Re: EN 010151 - Beacon Fen Energy Park

Boston Borough Council's - Deadline Six Submission – 12th January 2026.

The letter sets out Boston Borough Council (BBC) response to the Applicants Deadline 5 submissions for the above Project.

DRG No.	ST19595-082	REV	7	SUIT. CODE	
DRG SIZE	A1	SCALE	1:1,500	DATE	18/10/2023
DRAWN BY	JC	CHECKED BY	DS	APPROVED BY

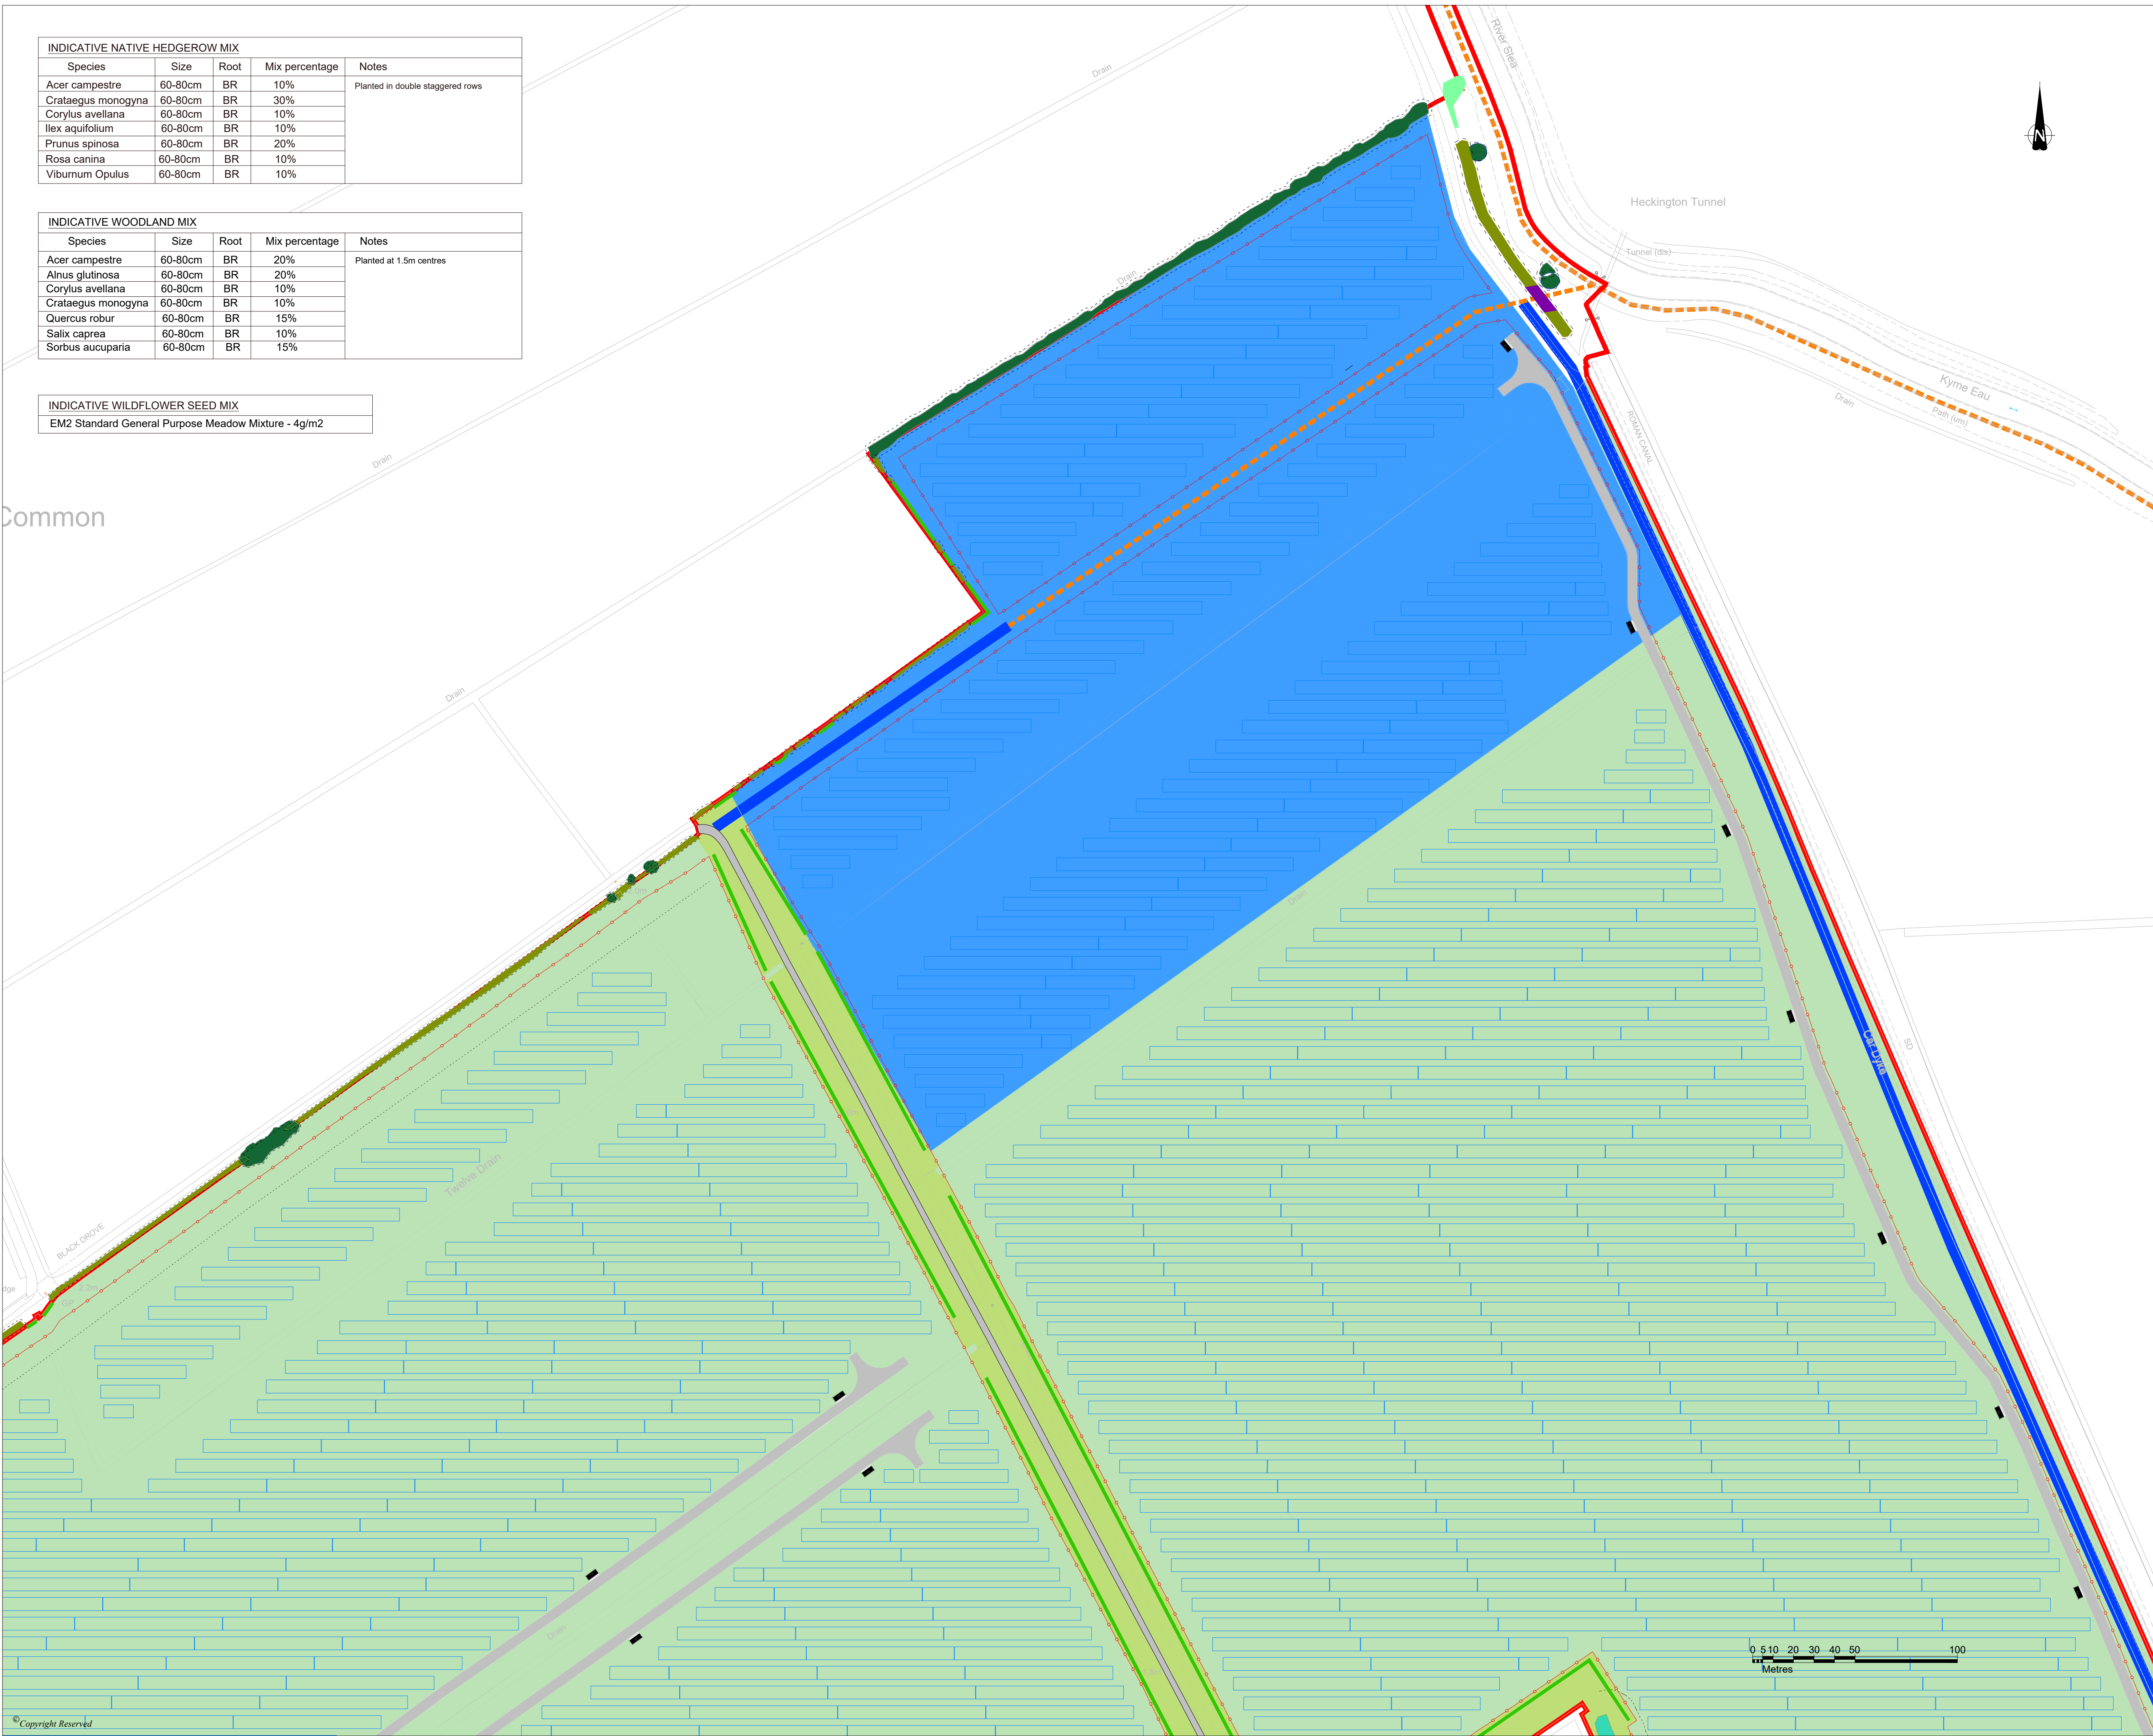
The Landscape Enhancement Measures included within the Change Request OLEMP (CR-016) and Change Request Landscape Strategy Plans (CR-021) at the existing Bicker Fen Substation are not included within the D5 OLEMP (REP5-026). BBC therefore requests that the OLEMP is updated to avoid confusion and understands that the Applicant will submit an updated OLEMP.

The Landscape Strategy Plan also references areas where vegetation is to be temporarily removed or temporarily lain to aggregate and, in both cases, reinstated. There is also reference to a restoration plan.

Figure 6.32 Vegetation Removal Plan Part 1 (Change Request)

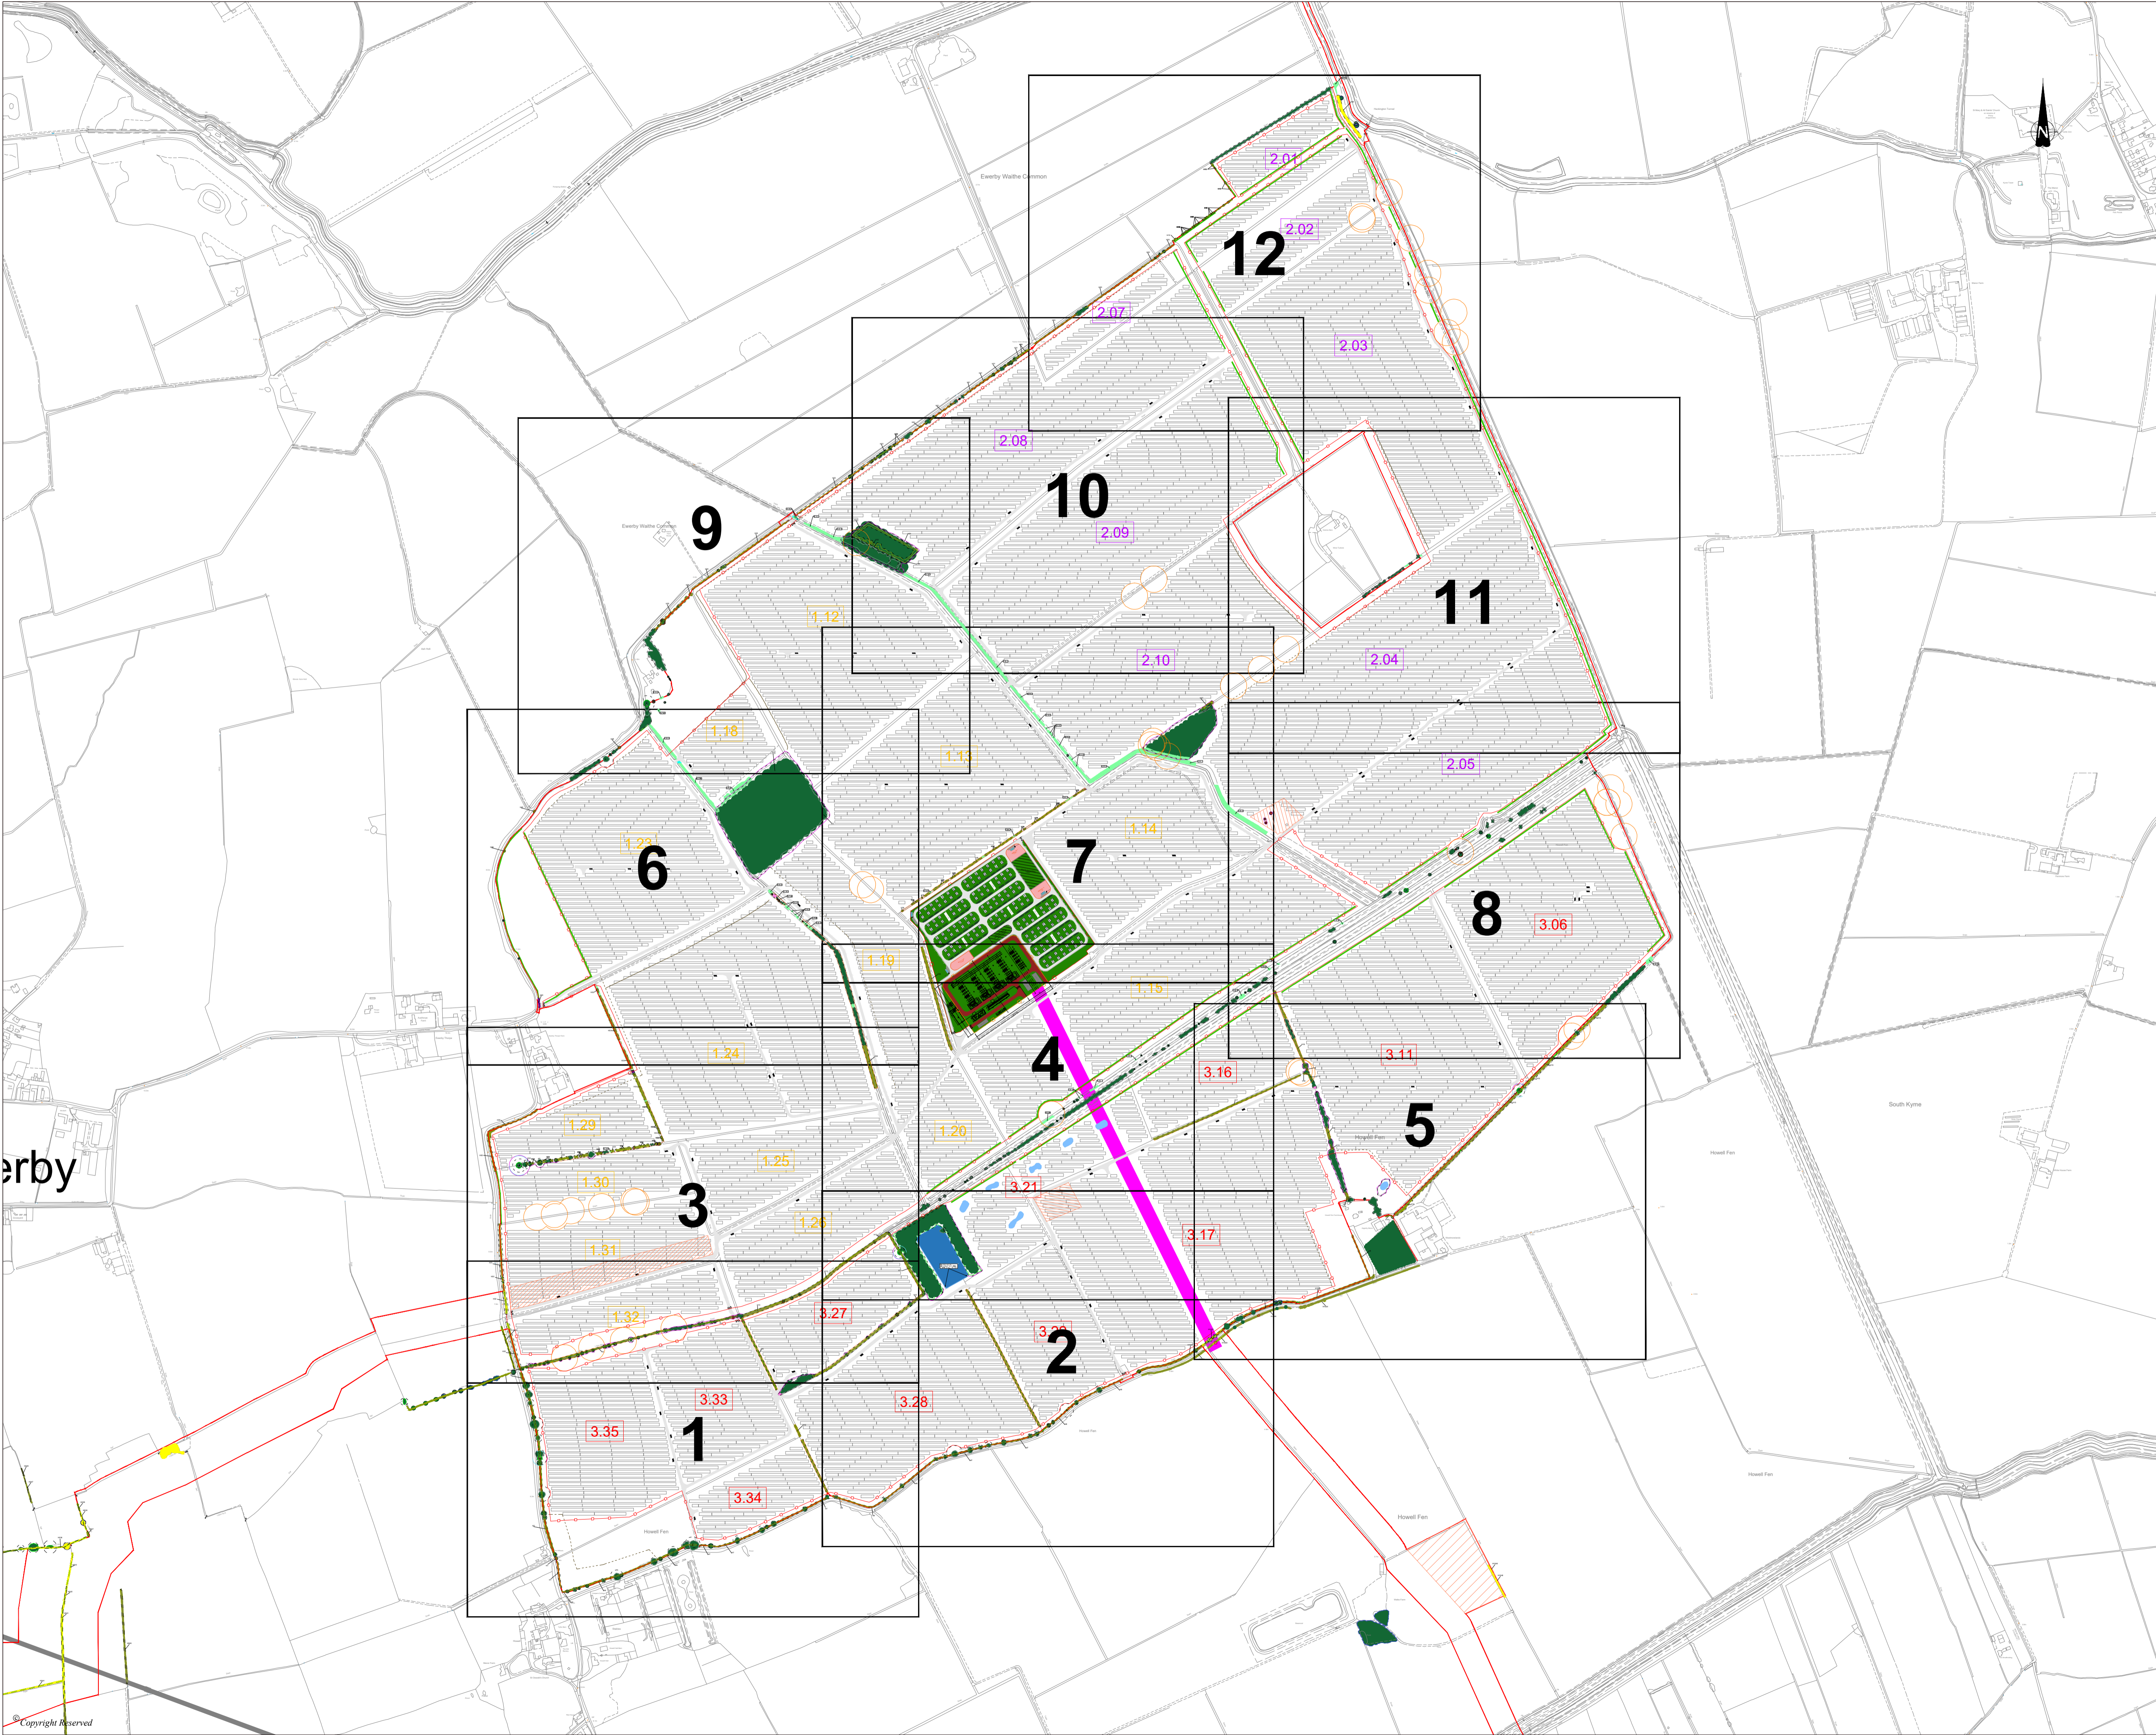
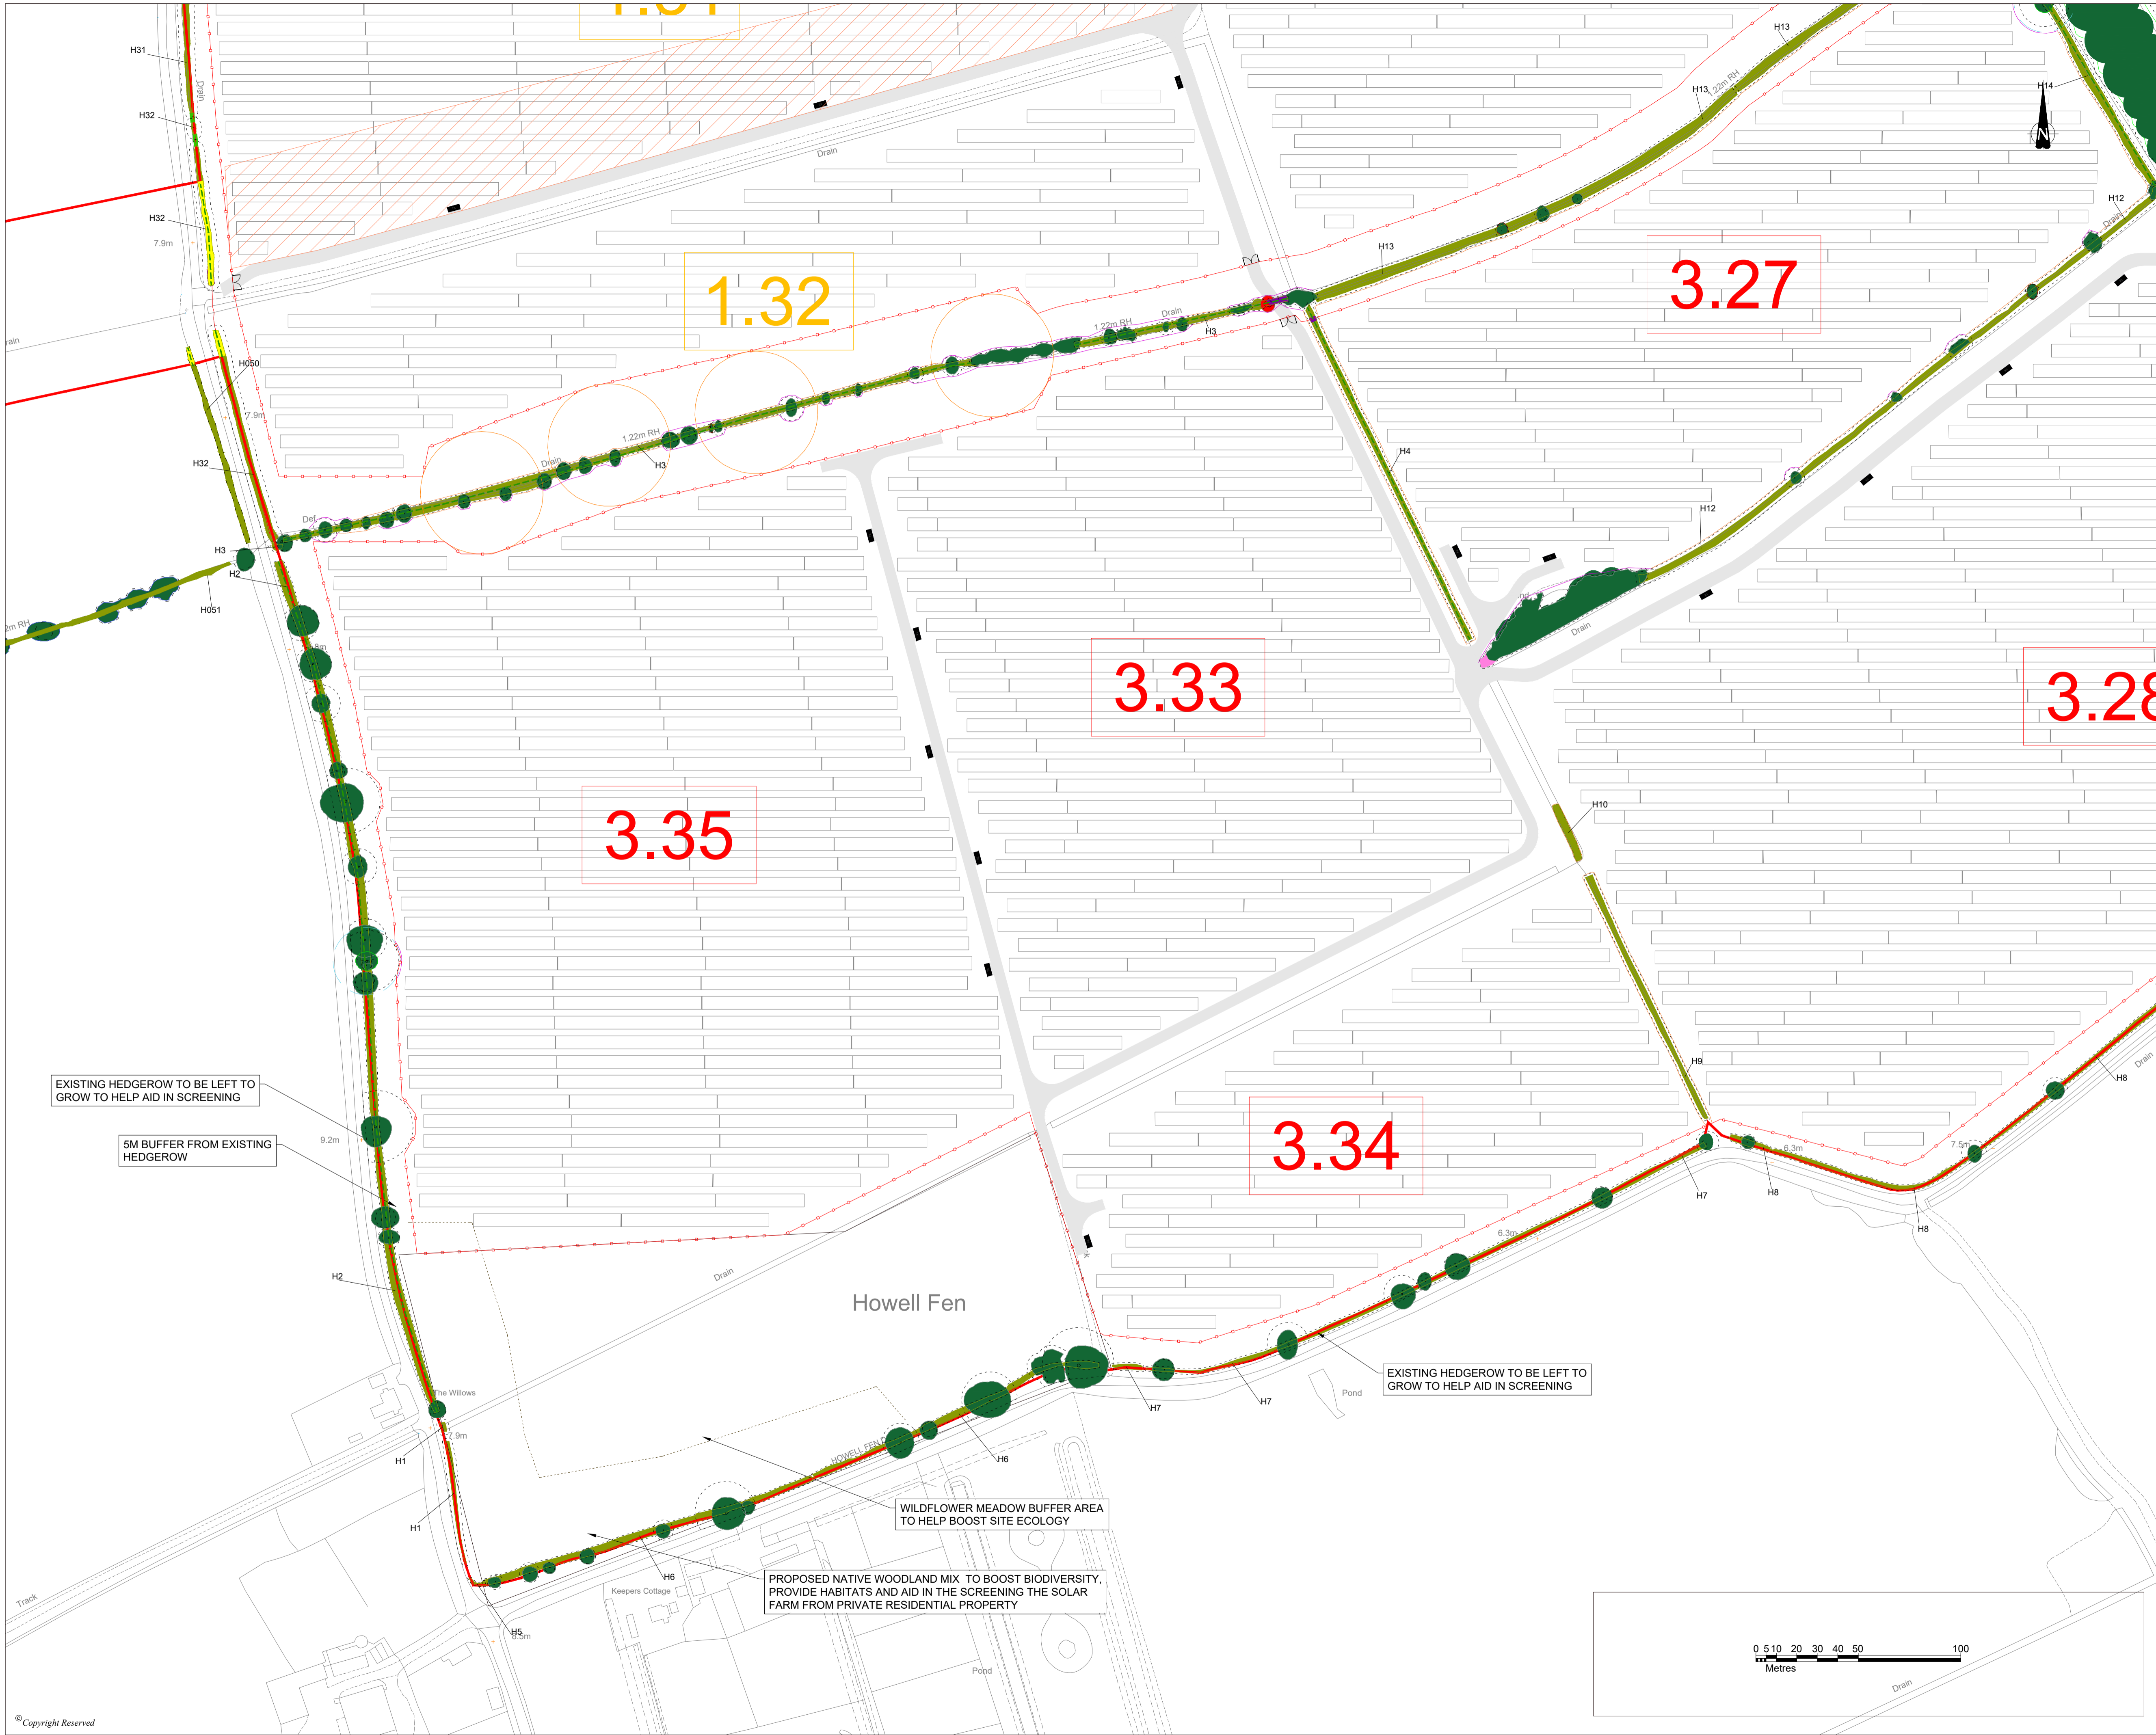
BBC notes that the Change Request accepted by the ExA introduces new infrastructure (Overhead line and Tower) and a revised OLEMP (CR-016) with a landscape strategy plans (CR-021) as well as revised Vegetation Removal Plans (CR-024).

BBC's consultation response to the Applicant in respect of the Change Request requested confirmation of the submission of and how a Vegetation Reinstatement Method Statement, in the event that Work No. 5C and 5D are temporarily be lain to hardstanding, be secured in the dDCO. BBC understands a commitment is to included within the OLEMP and secured by Requirement within the dDCO.
